APPLICATION BY AQUIND LIMITED

DEADLINE 7: RESPONSE TO THE EXAMINING AUTHORITY'S FURTHER WRITTEN QUESTIONS (REF: SE2.15.4) ON BEHALF OF THE UNIVERSITY OF PORTSMOUTH

25th JANUARY 2021

TITLE: **Application document reference 2.4 Low Resolution Works Plans Sheet 10 of 12**

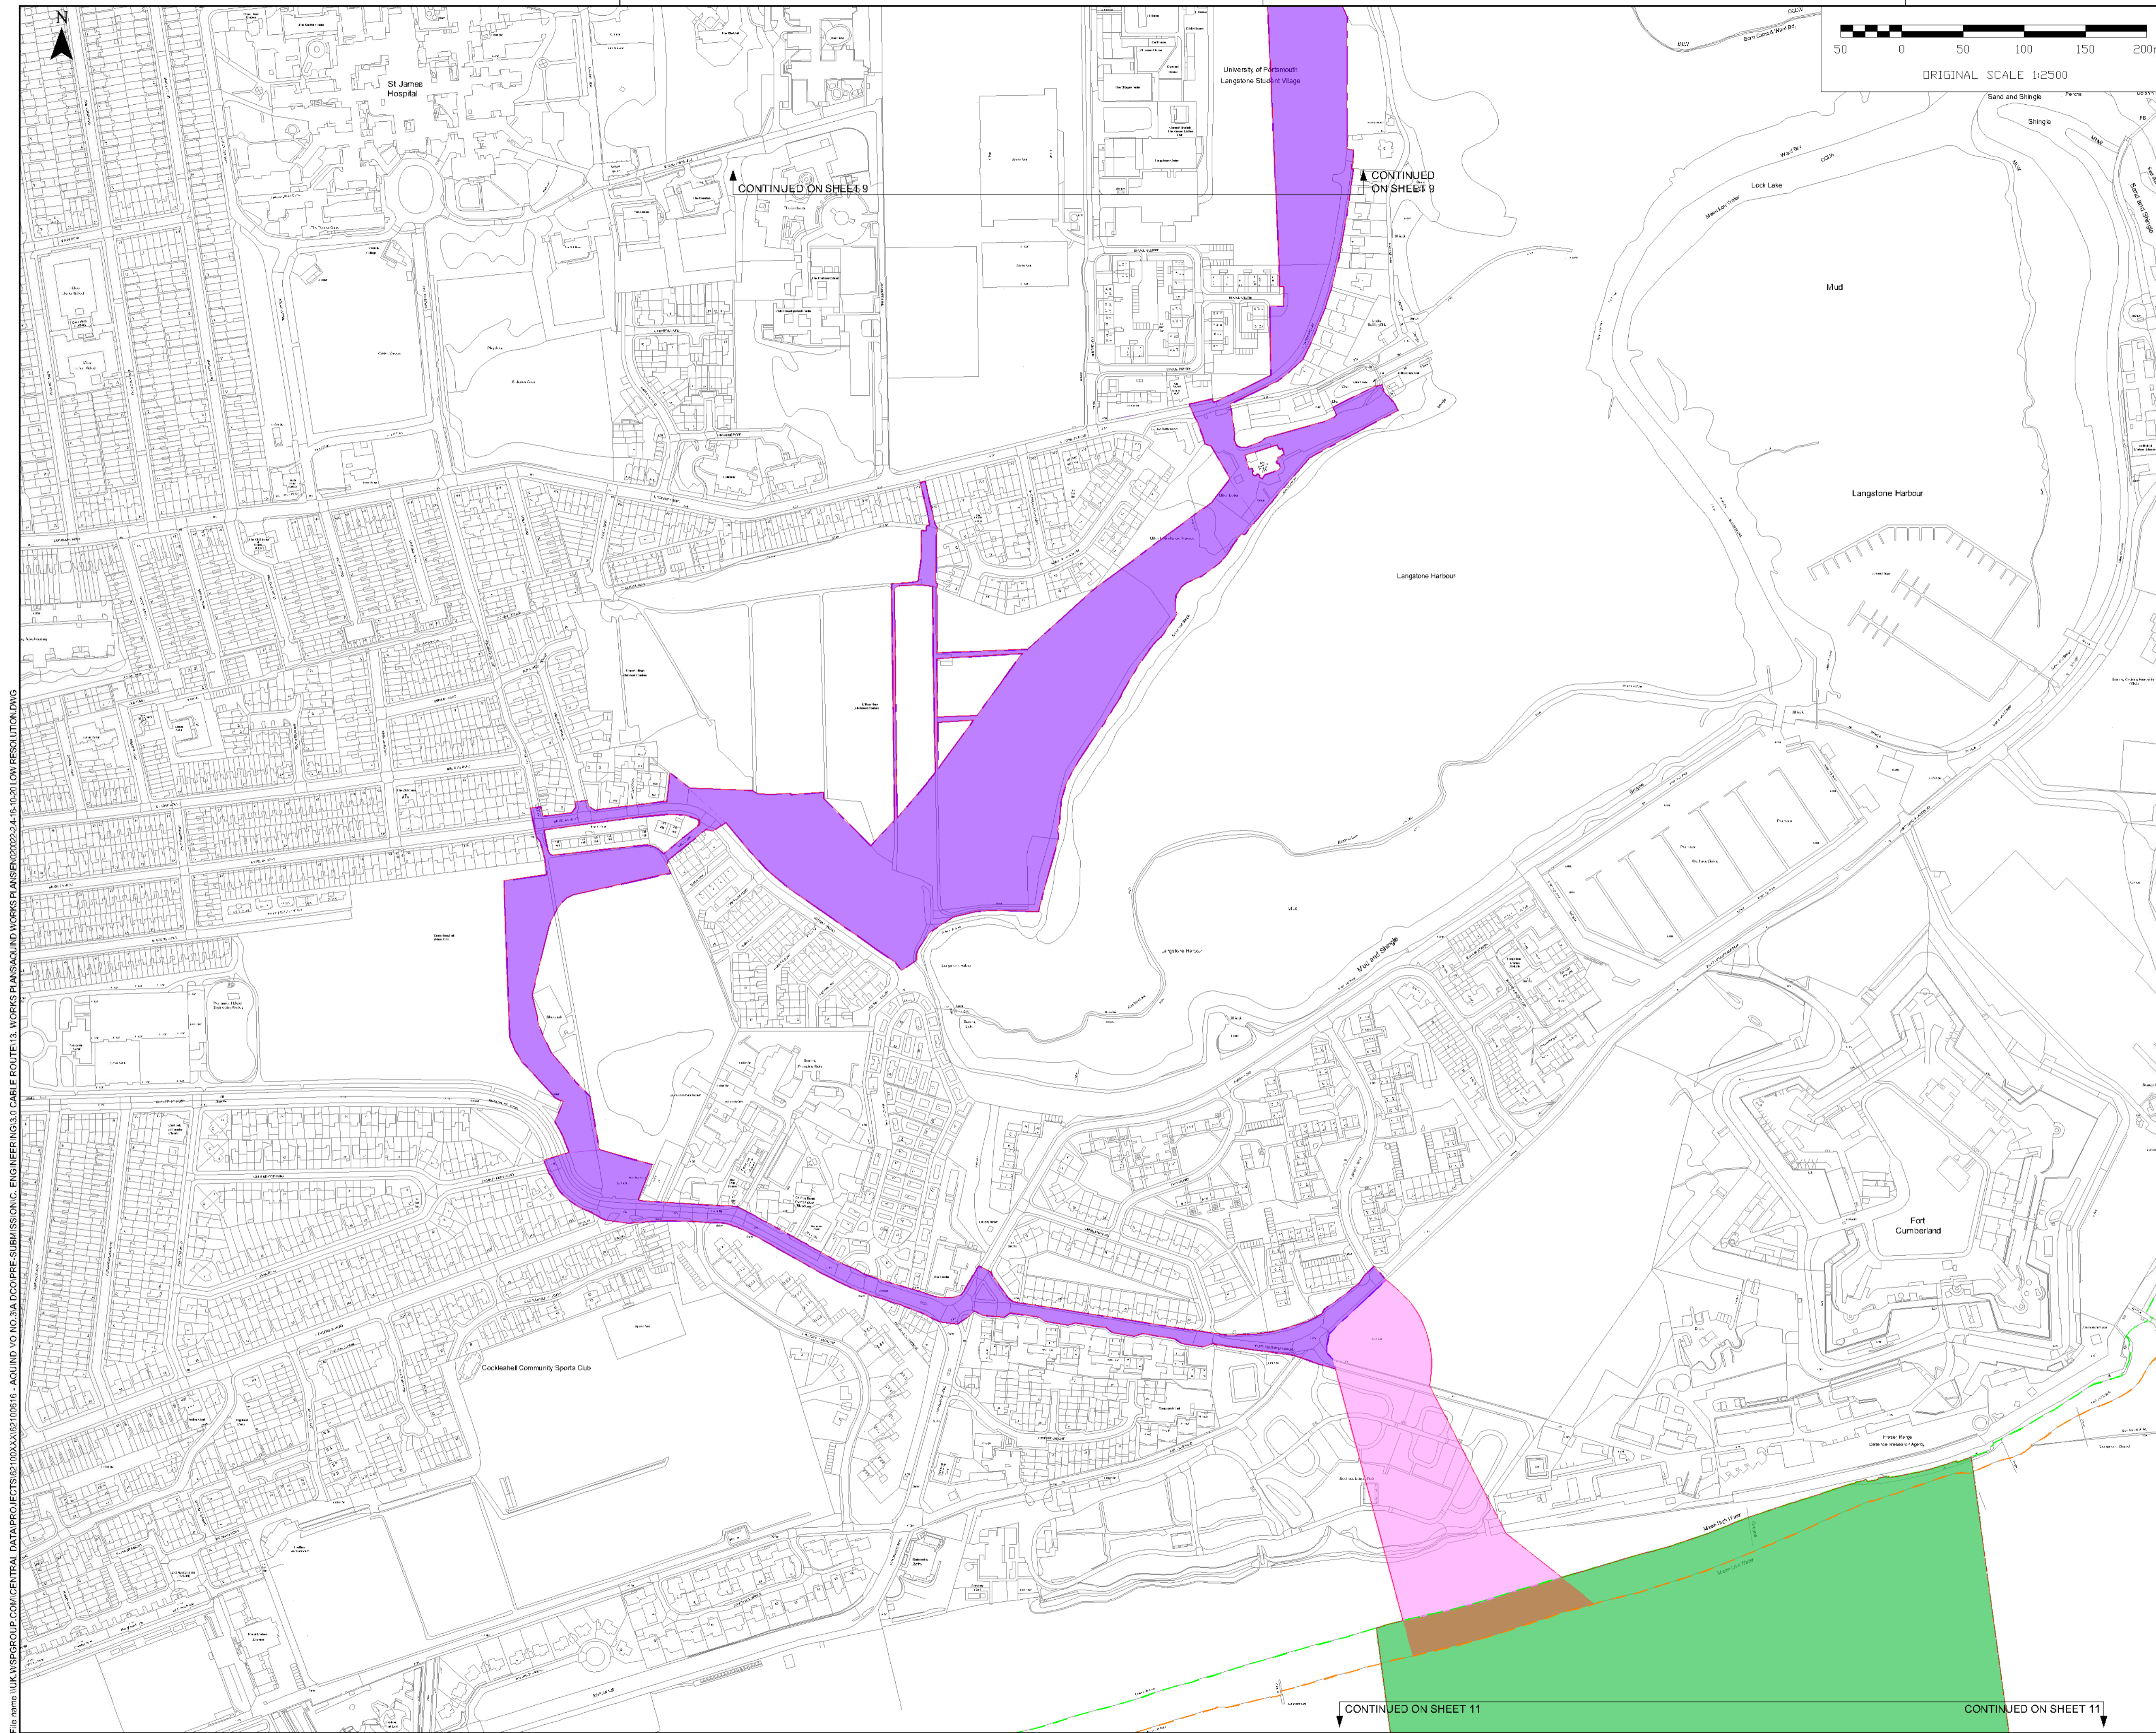
4. AQUIND ("the Applicant") submitted revised layout drawings (dated 16th October 2020) which we understand to be the most up-to-date works plans. As can be seen on sheets 9 and 10 of those revised drawings, there is land owned and operated by the University on the Langstone Campus which falls outside the purple shaded area identified as "Limits of Deviation for Work No. 4". This land accommodates 3 sports pitches which due to their current alignment extend part into and part outside the area of the Order Limits.

8. Our submissions on behalf of the University to date have demonstrated that the worst case scenario would be that for the full stated 16 weeks of construction (as a minimum) all 3 of these pitches will not be able to be used. As such, there is no ability for the University to operate these pitches at even partial capacity during construction works.
